June 11, 2024

**Re: Alvarado Roofing Headquarters at 4015 Hawkins St. NE  
Erosion and Sediment Control Plan  
Engineer's Stamp Date 5/20/24 (D17E008)**

Sheet Title:
LANDSCAPE PLAN

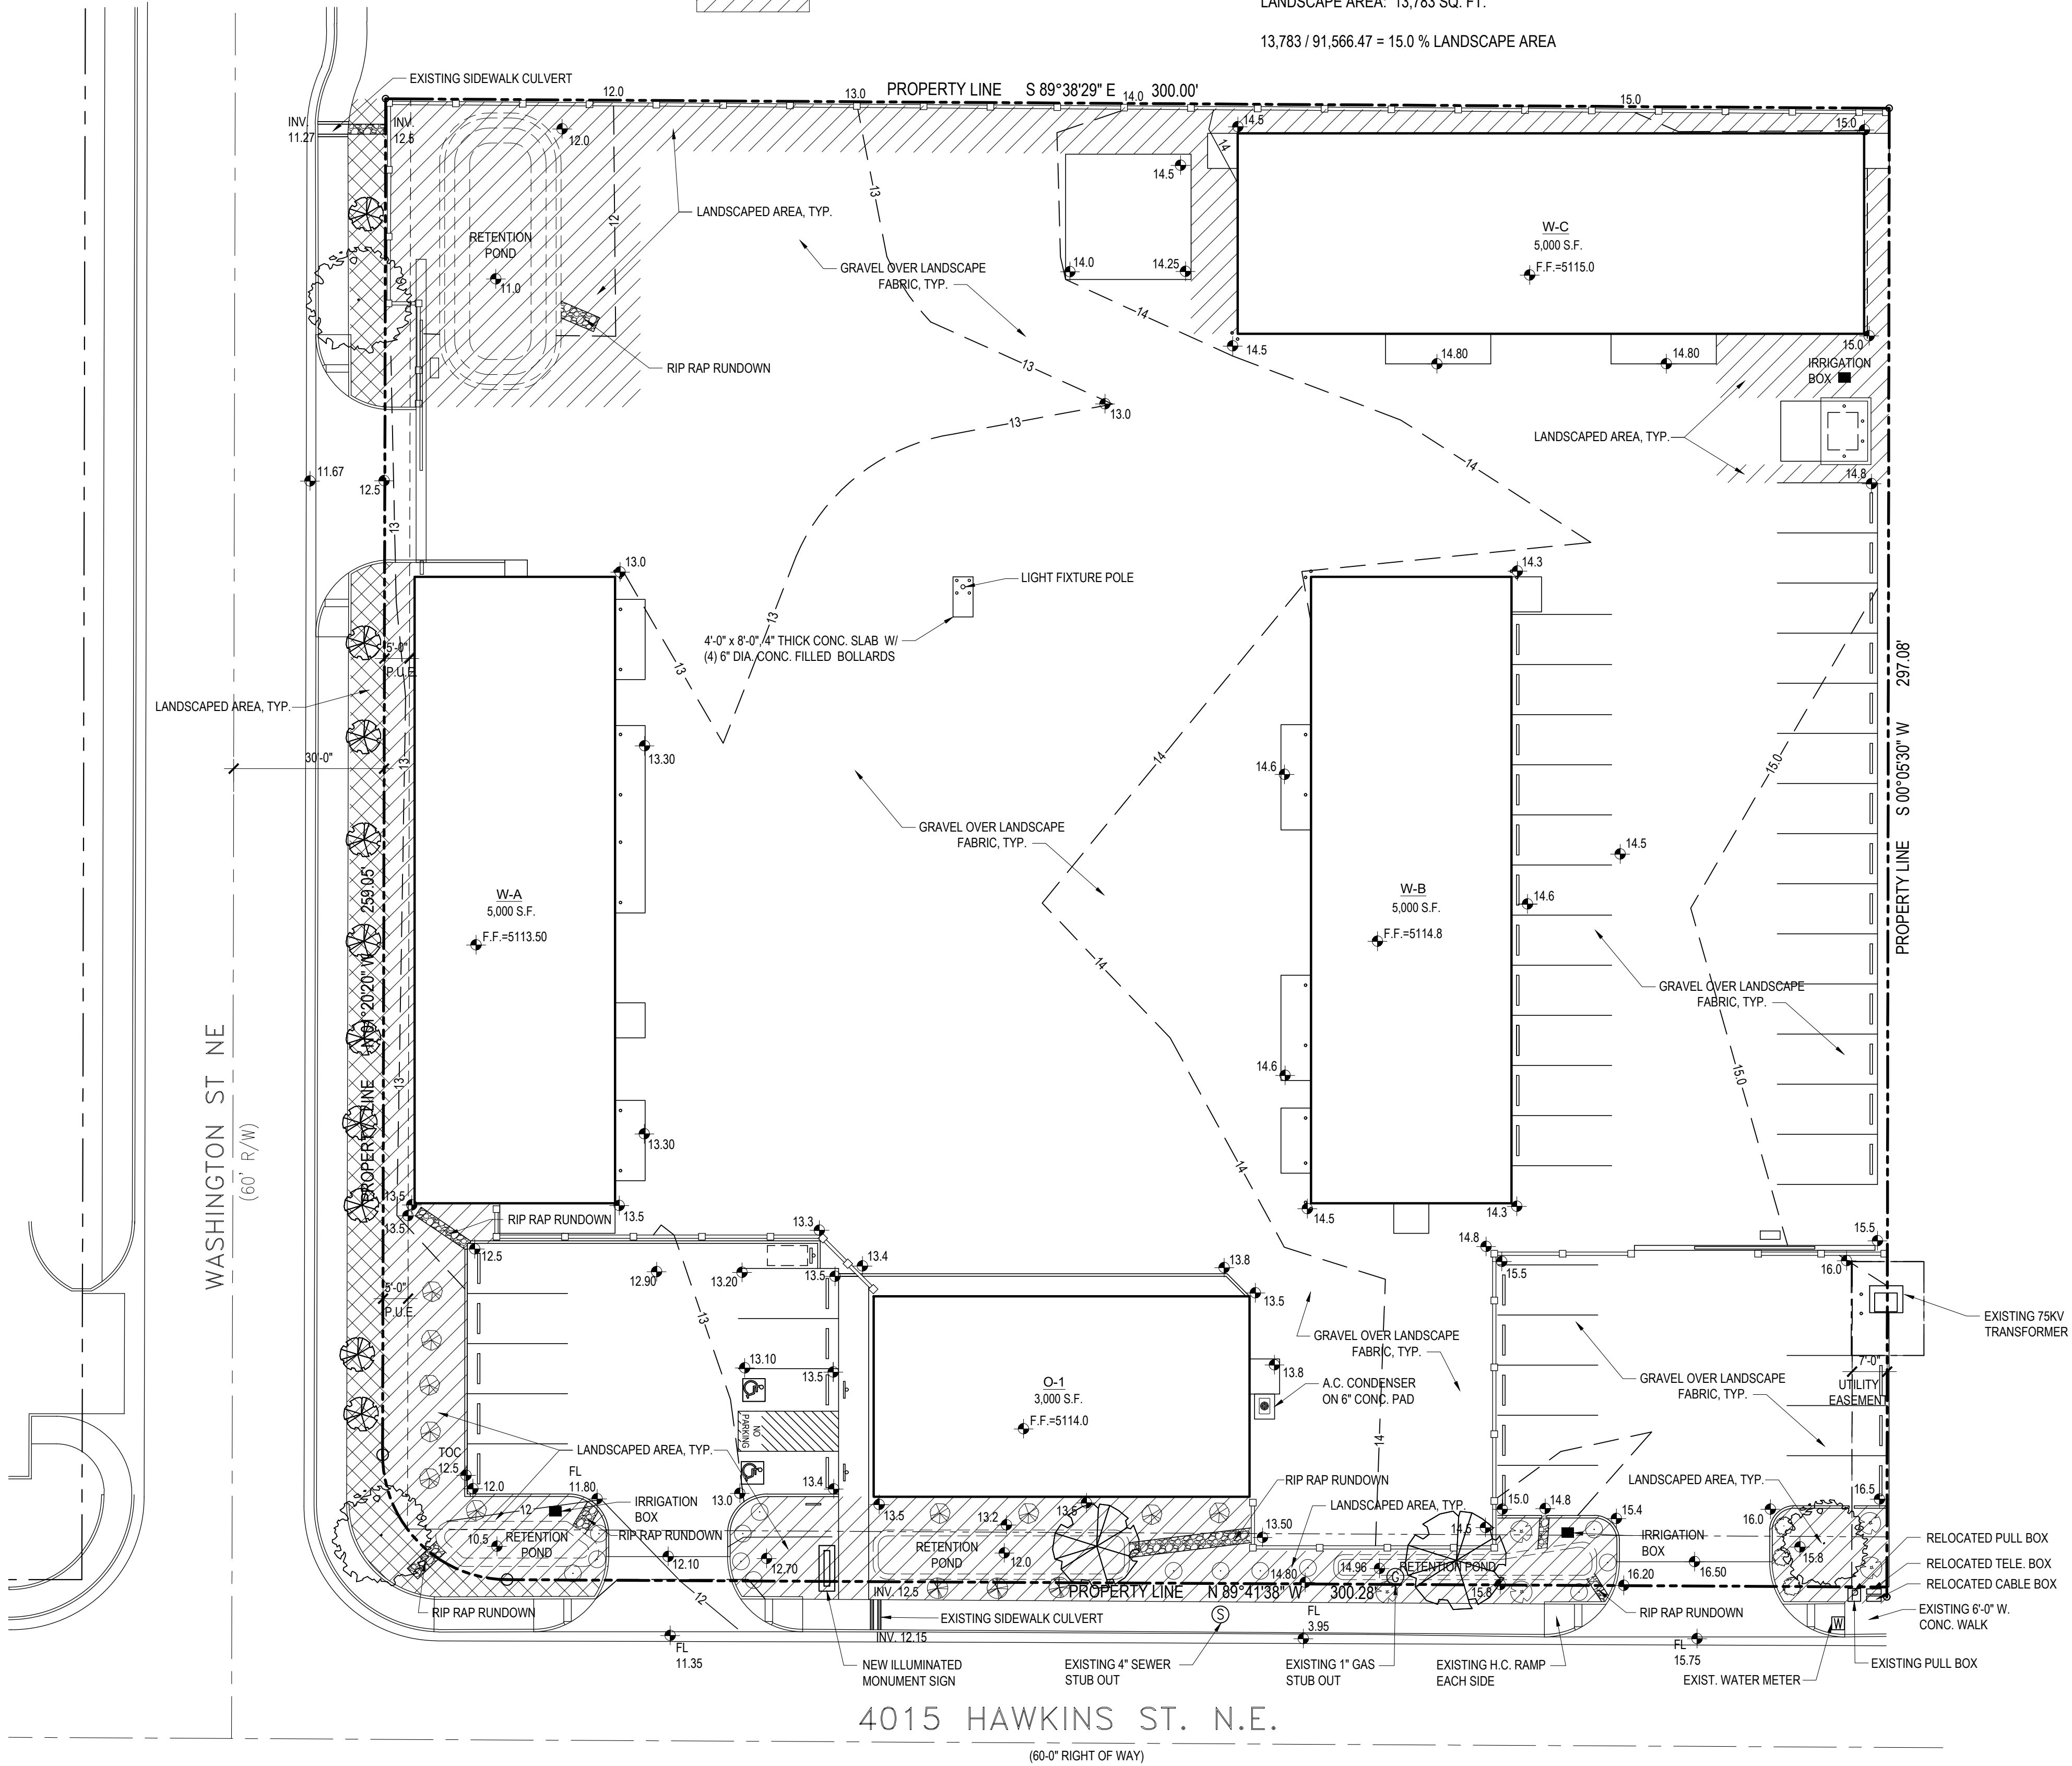
5. The SWPPP must include site-specific interim and permanent stabilization per CGP 9.6.1.c.i. The Landscape Plan can be used to satisfy this requirement and should be submitted separate from the ESC Plan with the application to the Stormwater Quality Section of the Planning Department and they should be included in the SWPPP. Provide a specification on the ESC Plan for any disturbed areas not covered by the Landscape Plan.

GRADING & DRAINAGE PLAN

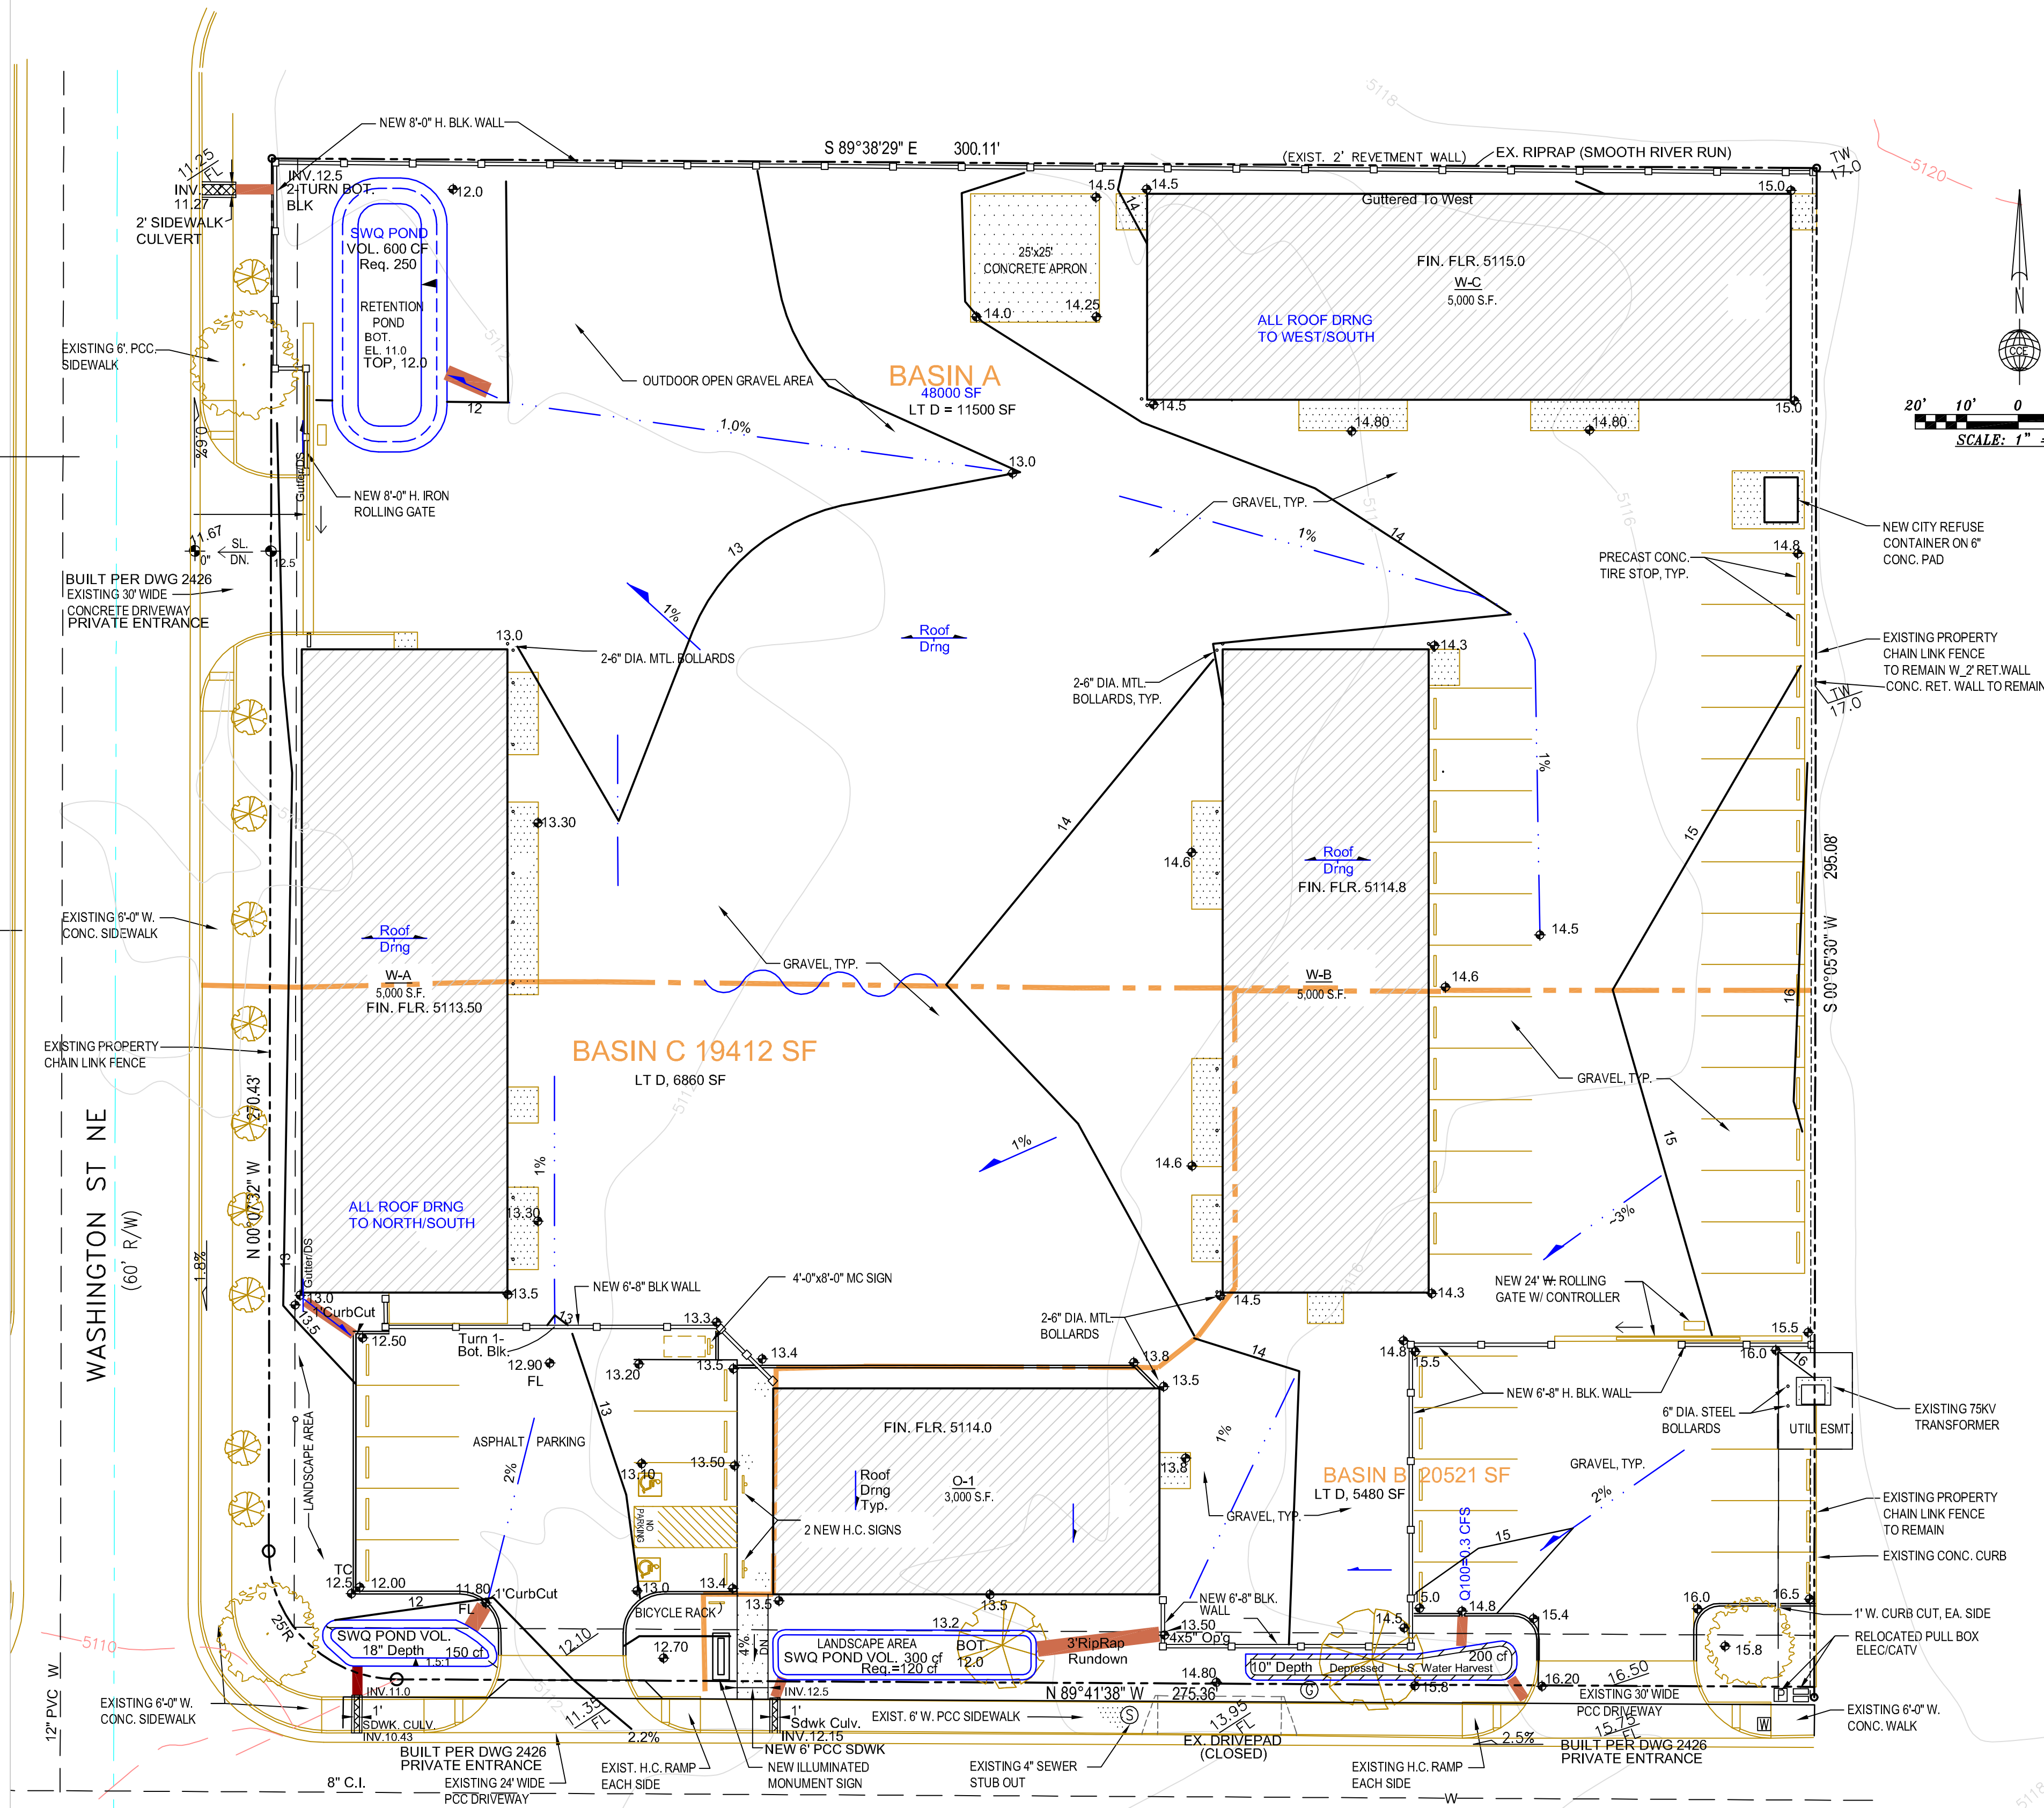
3. The ESC Plan title block and professional stamp are missing from sheet 4 of 6.
4. Consider relocating the Construction Exit from Washington St., the low side of the site, to Hawkins St. to avoid gaps in the perimeter control required by CGP 2.2.3. To prevent stormwater from circumventing the edge of the perimeter control, install the perimeter control on the contour of the slope and extend both ends of the control upslope (e.g., at 45 degrees), forming a crescent rather than a straight line per CGP 2.2.3.b.
